MMC St. John Employee Garage - LIII Site Plan Conditions of Approval Submittal for Issuance of Building Permit

Wed, Oct 3, 2018 at 10:19 AM

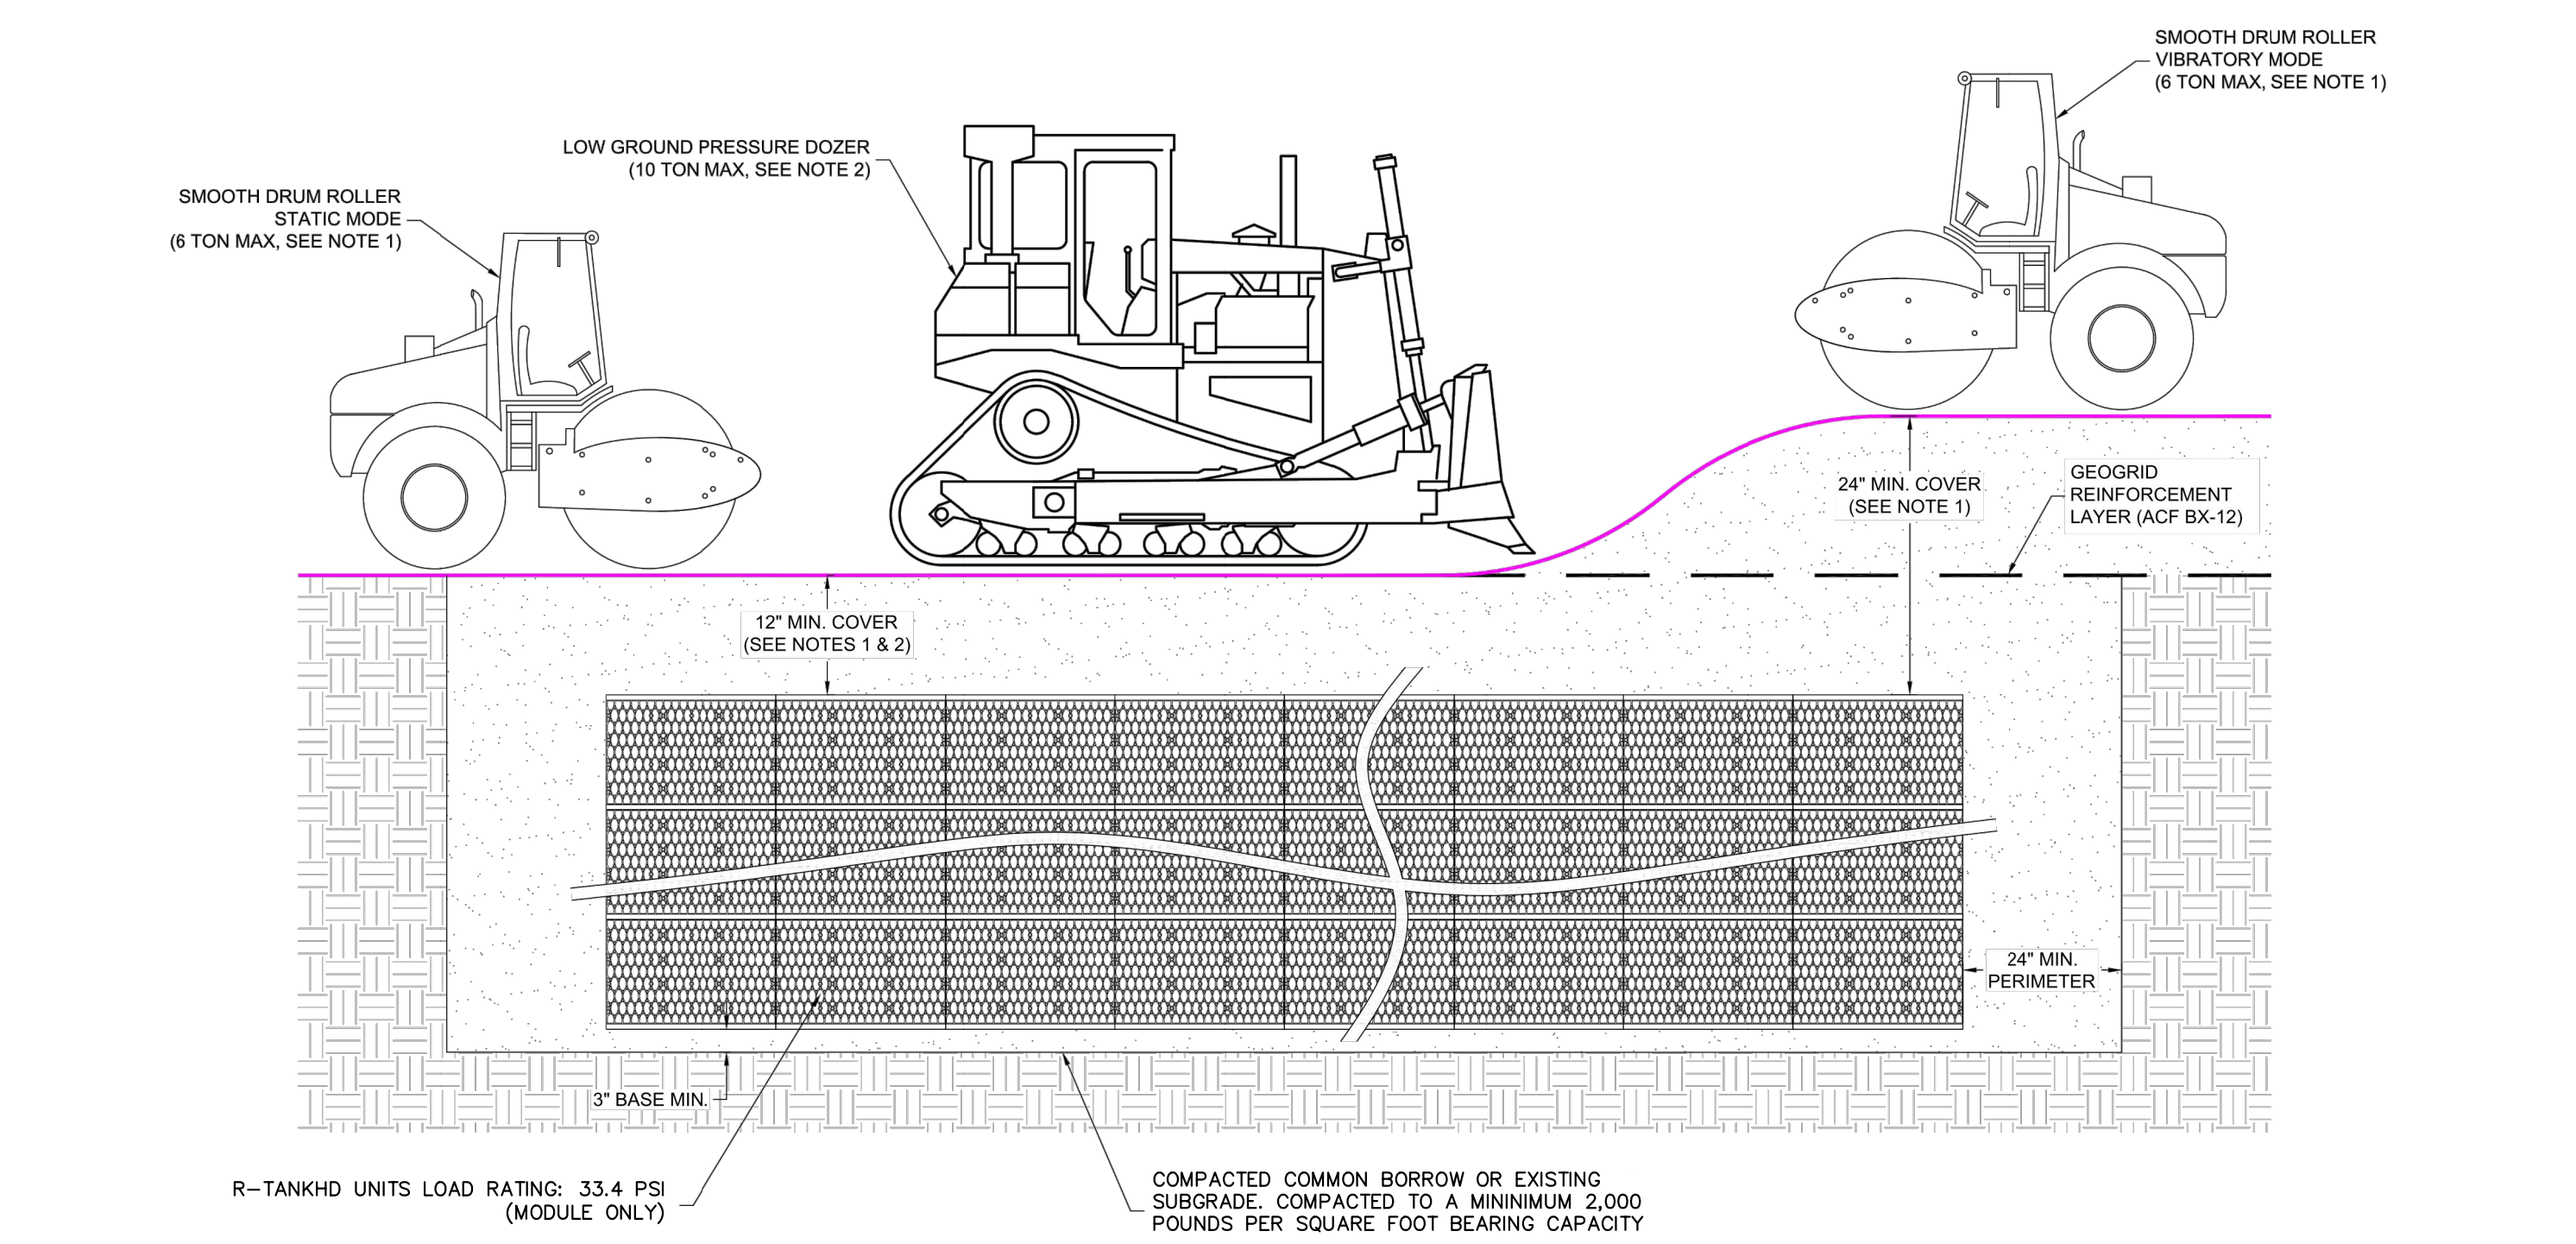
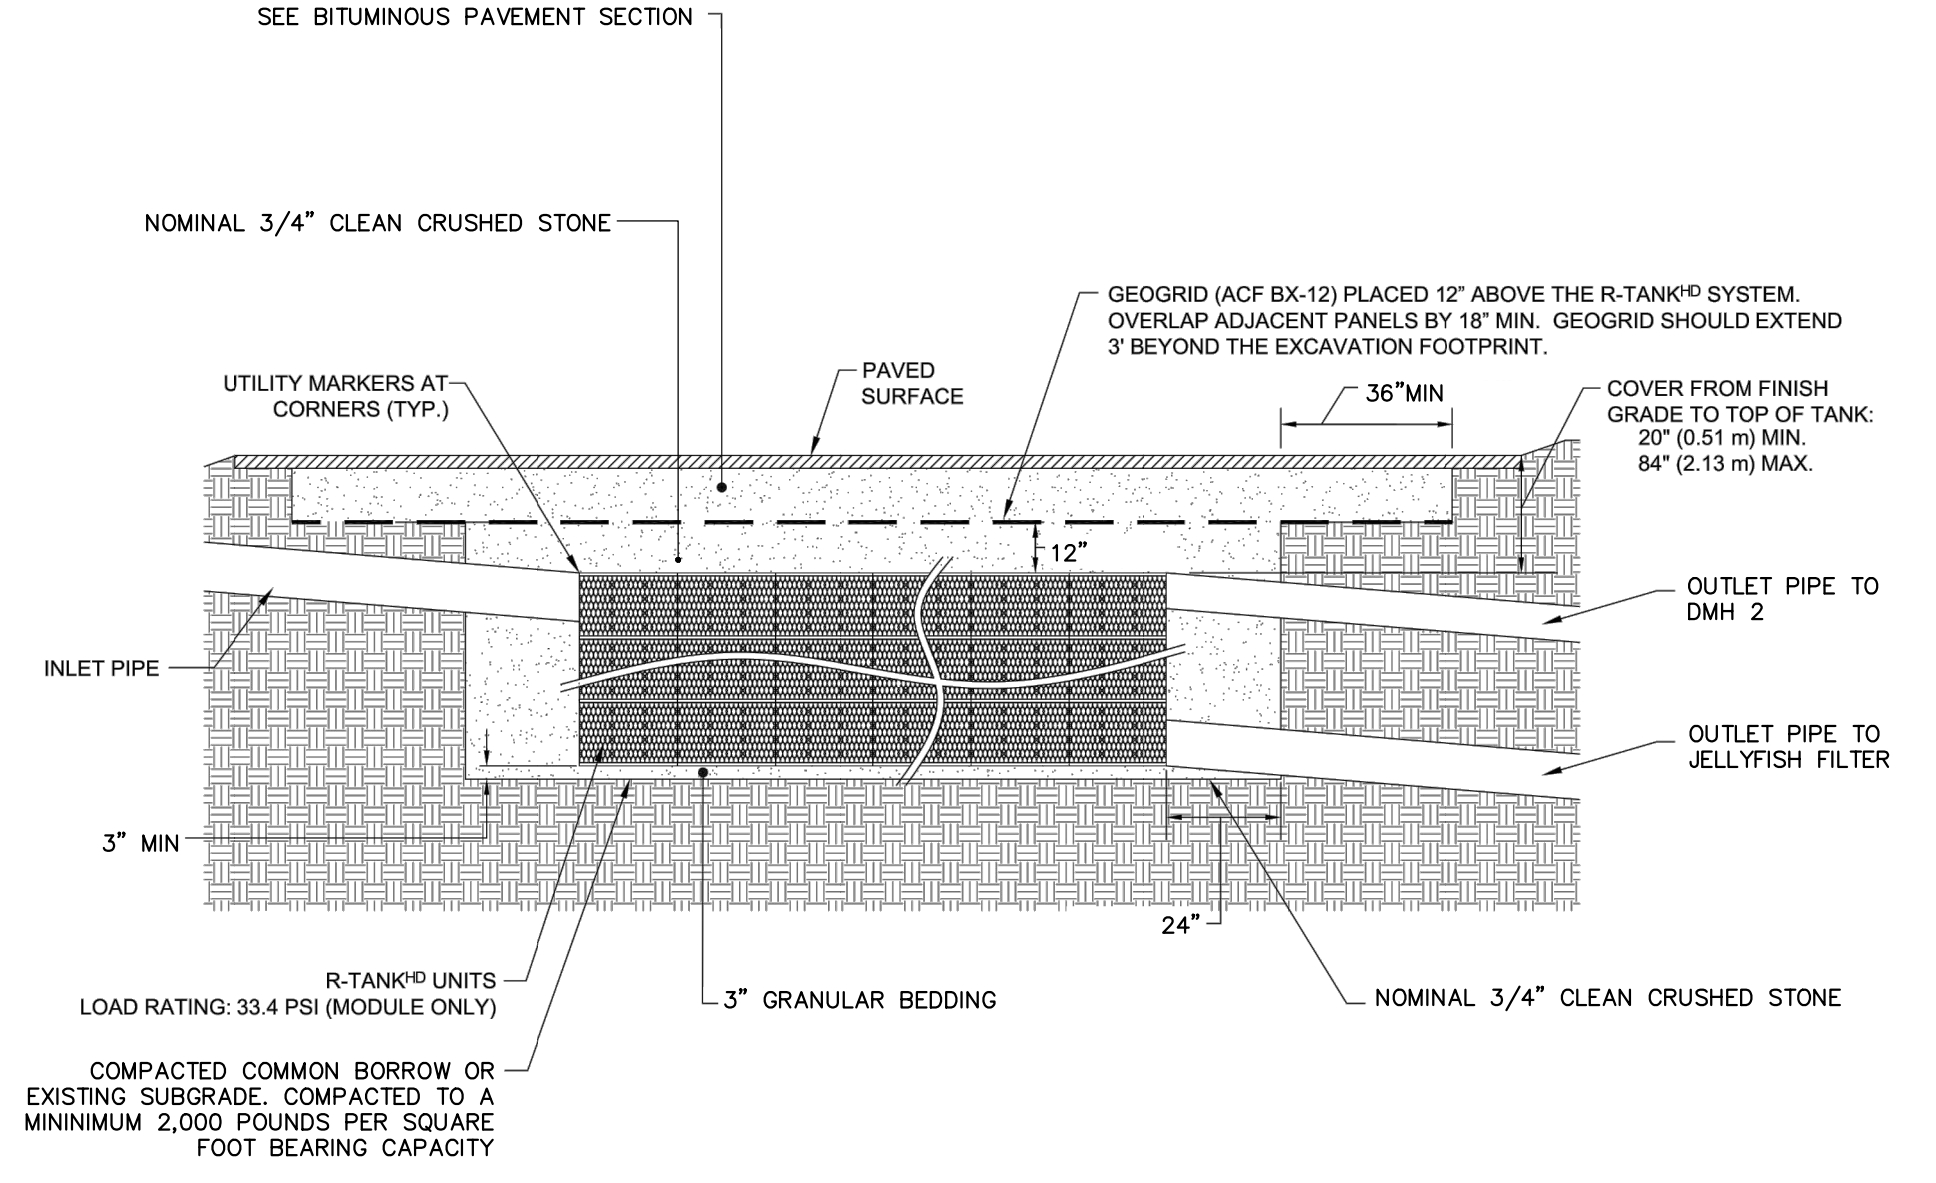
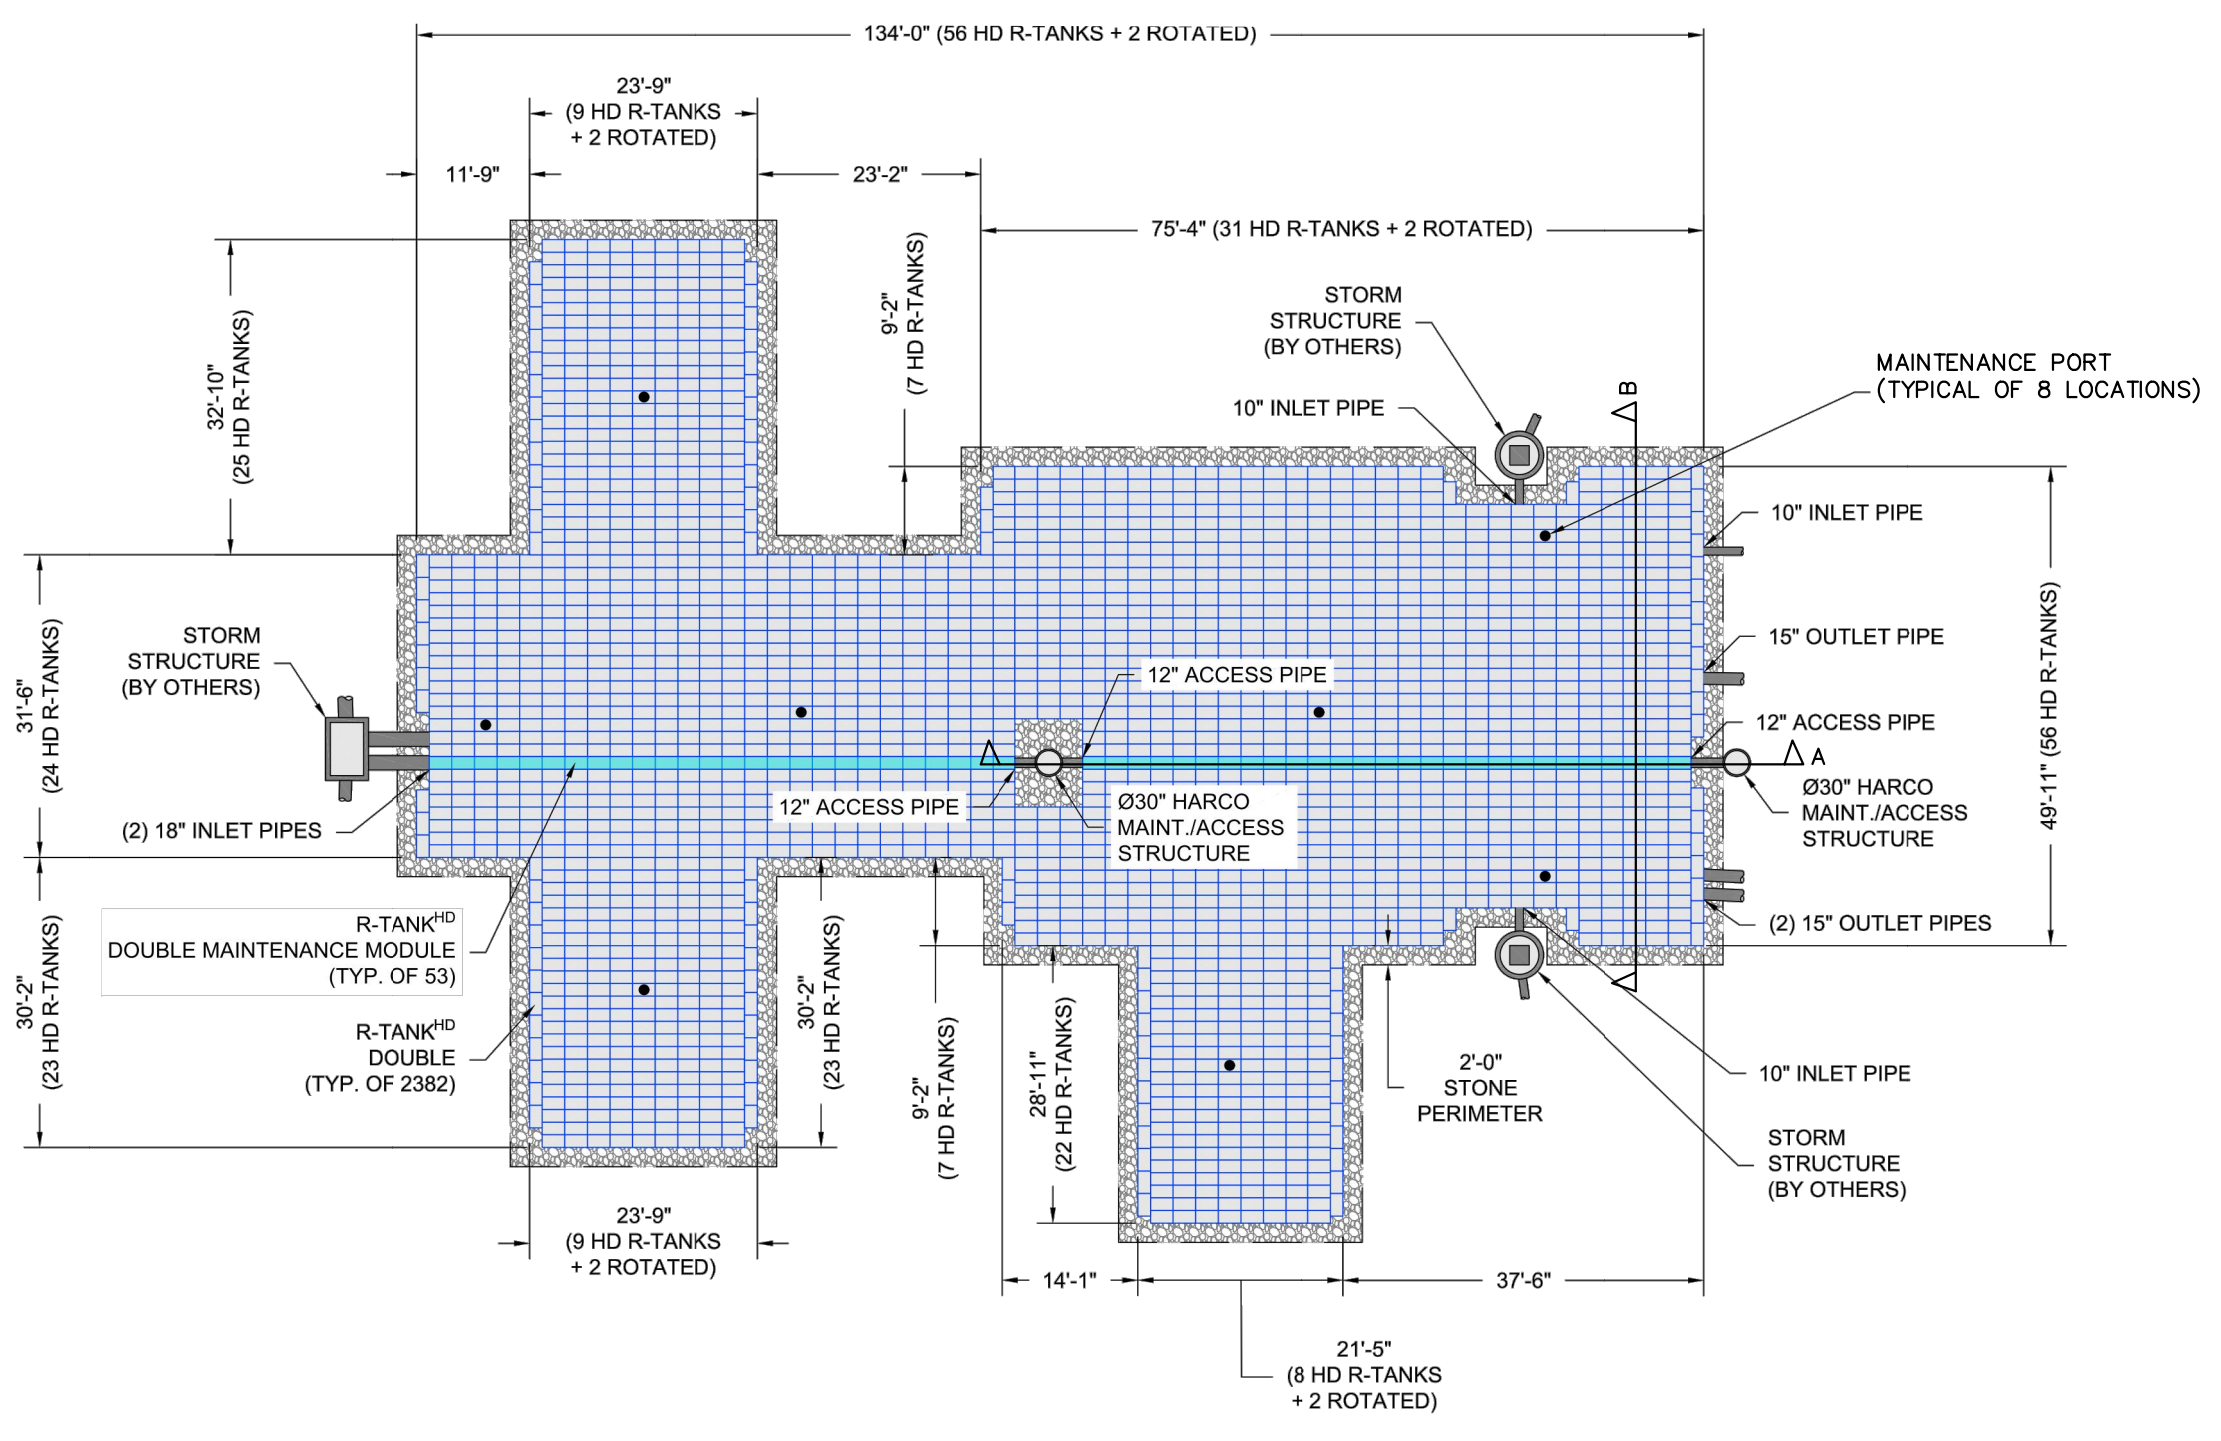
- i. **Documentation of design approval from the manufacturer of the stormwater treatment system:** I searched through the files uploaded to e-plan after the last submission and could not find a letter. Please let me know if it would be appropriate for me to call or e-mail Mr. Senus directly, as it may be a quick conversation to confirm the file location.
- ii. **Revised plans addressing slope inconsistencies:** The applicant has addressed this item, no further comment.
- iii. **Regarding the oil/water separator at the elevator:** The applicant's plan of coordinating final acceptability with DPW is appropriate. We agree that hydraulic elevators are more of a concern, but there is still grease and other contaminants in the elevator shafts and a potential for pollution.
